February 22, 2011

**Re: Brunacini Journal Center Tracts A-2-A and A-3-A
Preliminary Grading and Drainage Plan
Engineer's Stamp dated X-X-XX (D17/D003AA7)**

Based upon the information provided in your submittal received 2/10/2011, the above referenced plan can not be approved for Site Development for Building Permit action by the DRB until the following comments are addressed.

PRELIMINARY GRADING AND DRAINAGE PLAN

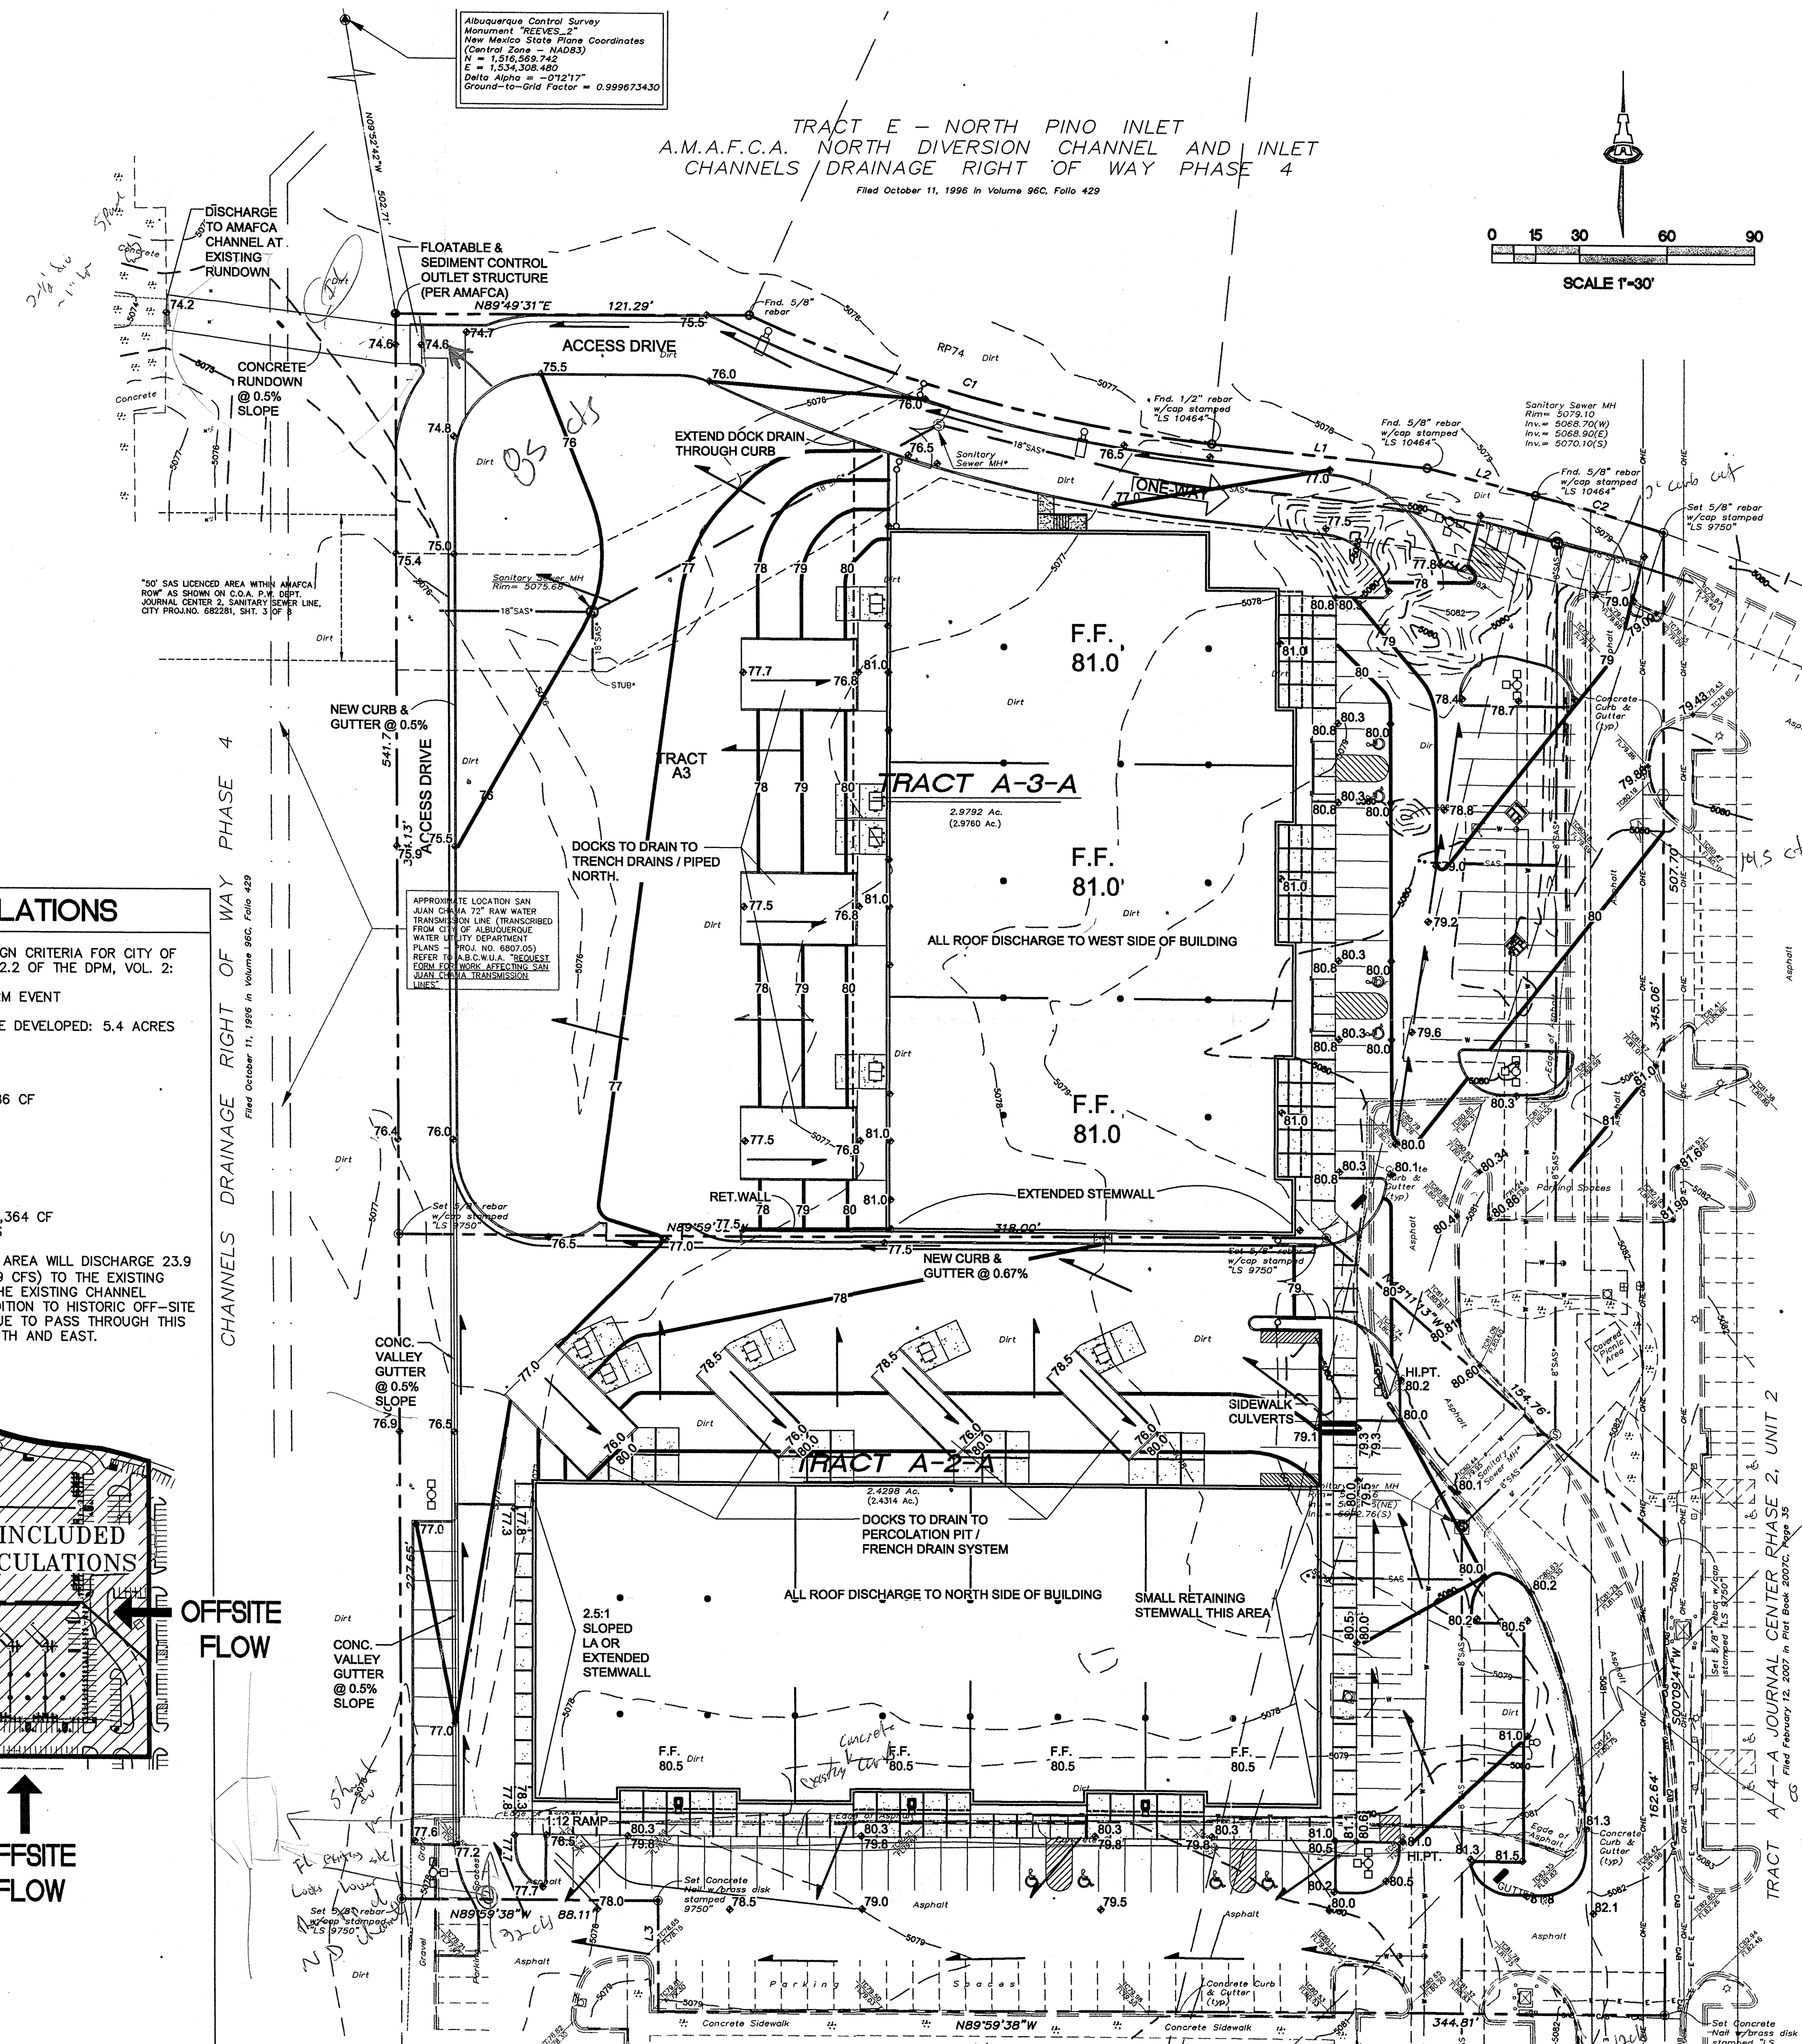
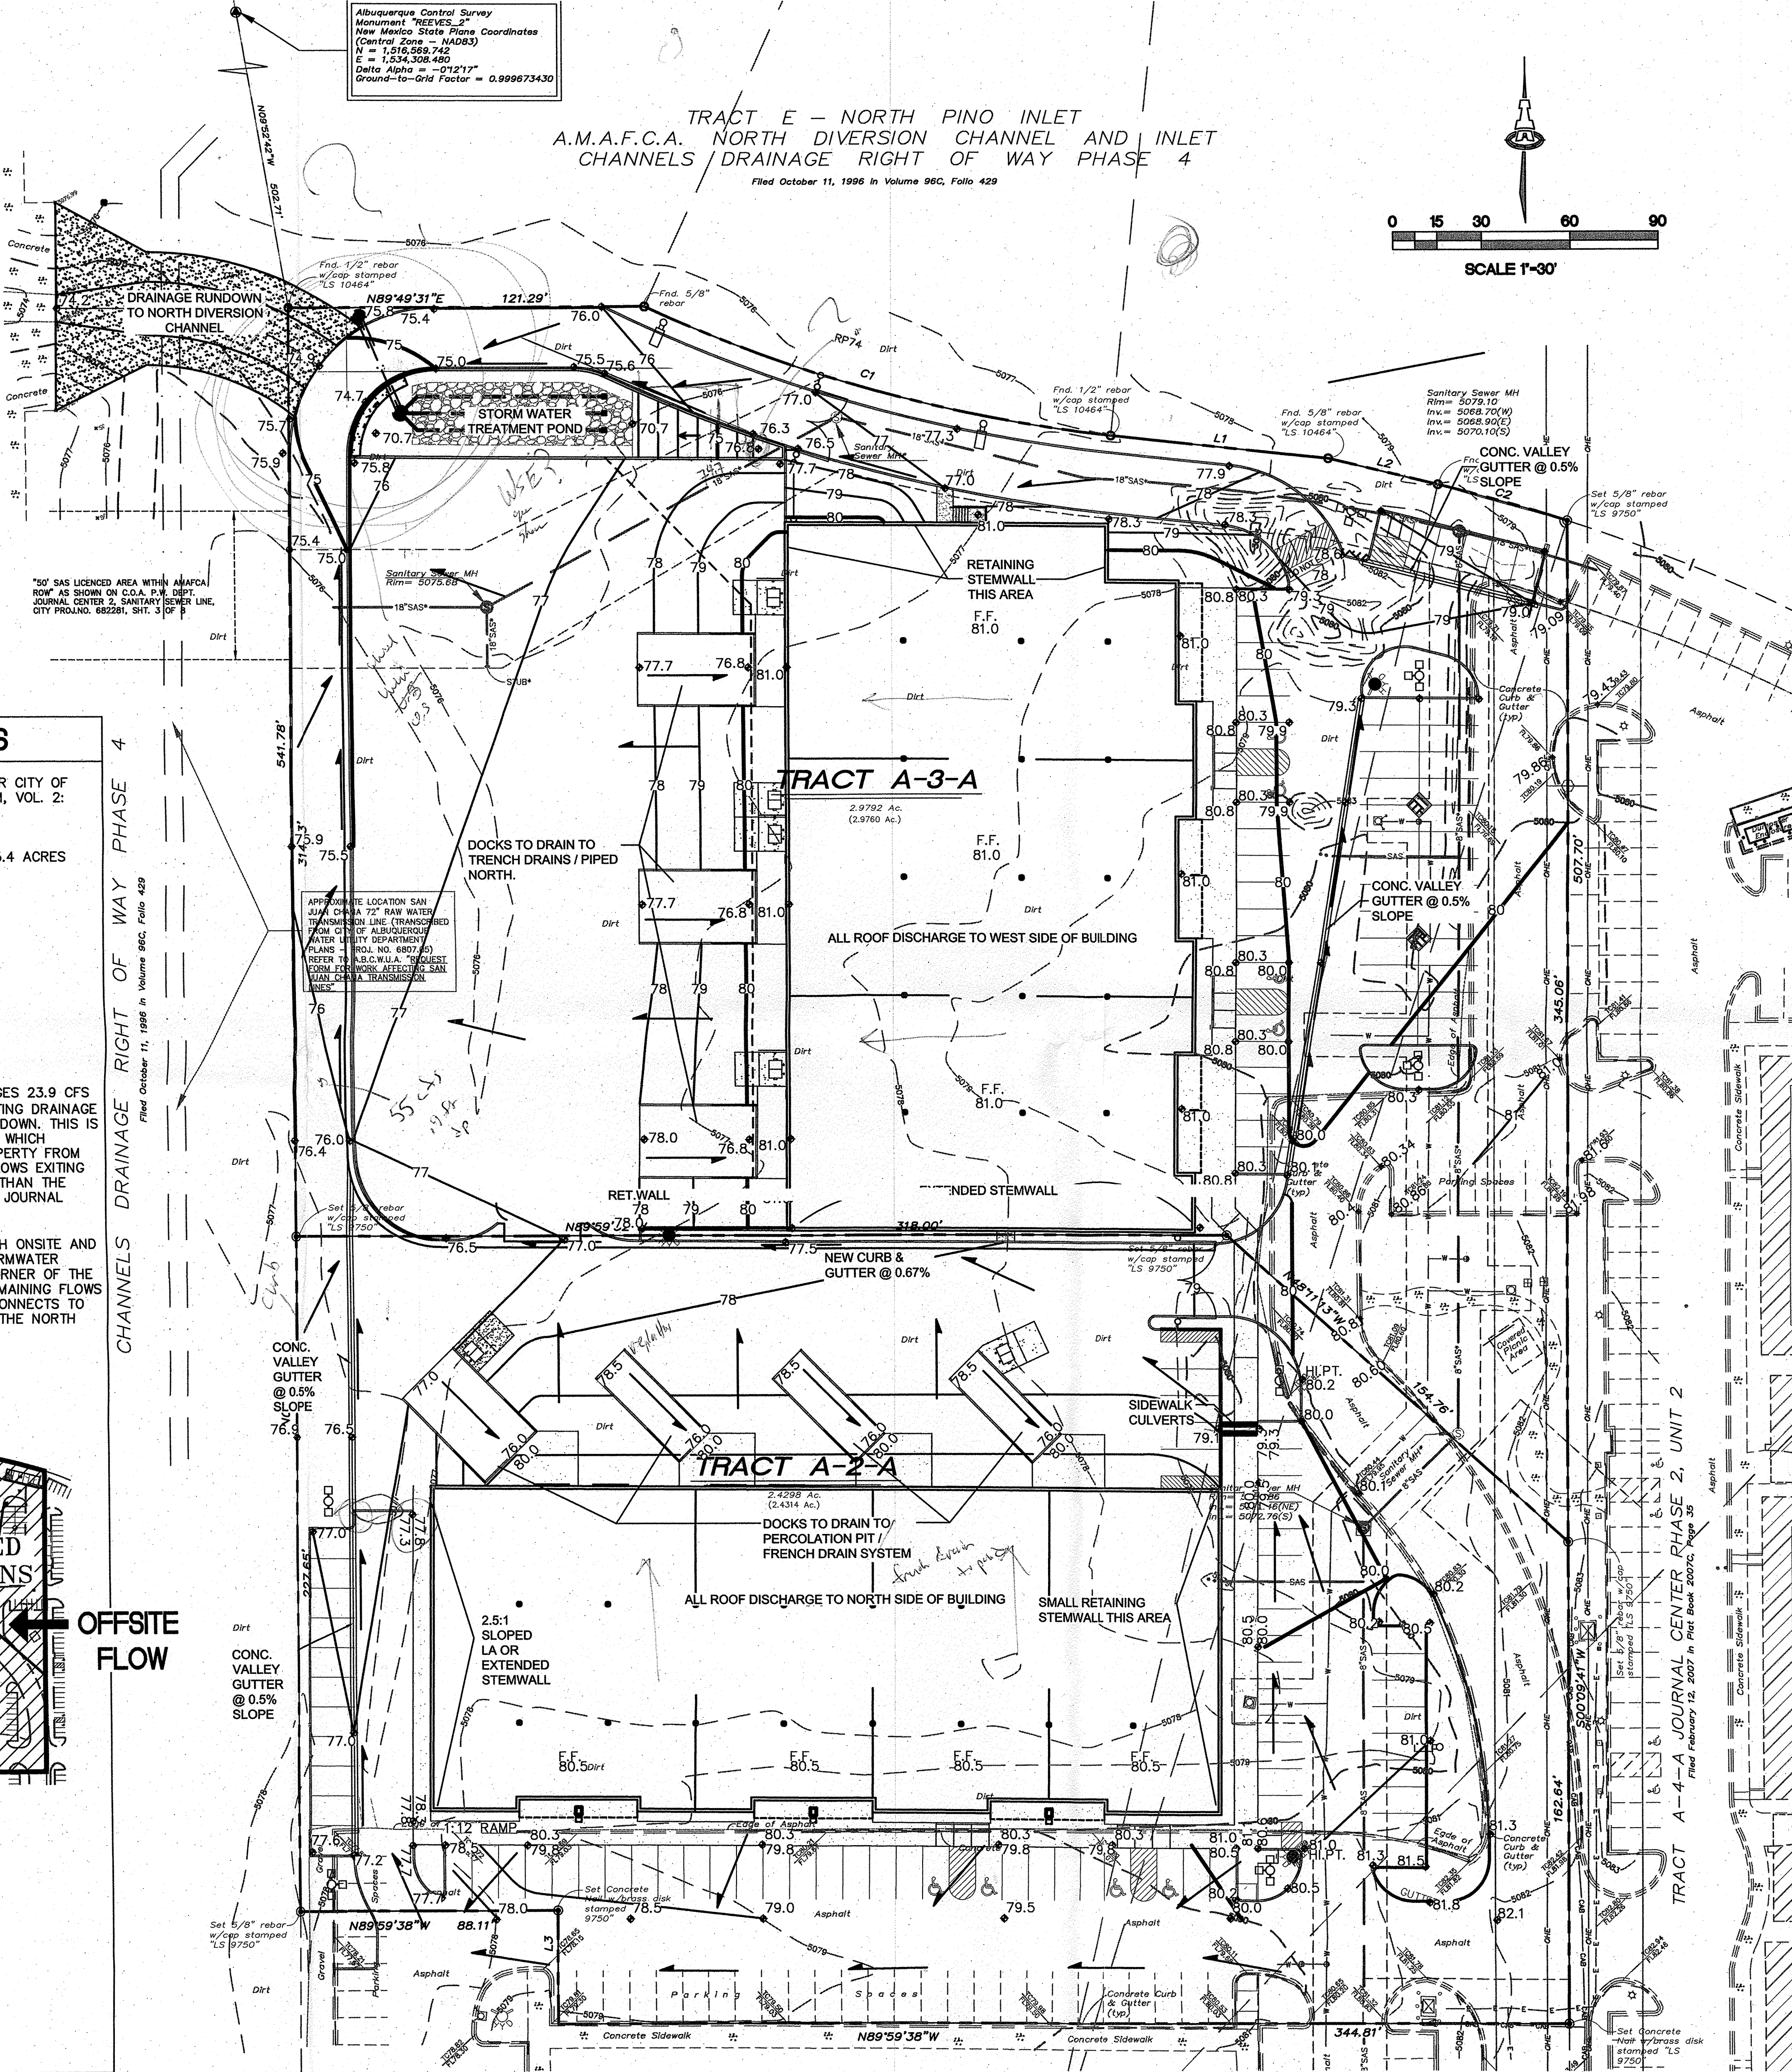
- We need the plans to be stamped, signed and dated.
- We would like for the valley gutter to be extended to the treatment pond area, or more of a slope in the internal access road.
- I believe that a curb opening in the access road just east of the bend would be much more beneficial in accepting flows from the east parking lots.
- The concrete rundown to the North Diversion Channel side inlet is required to be on an Infrastructure List.
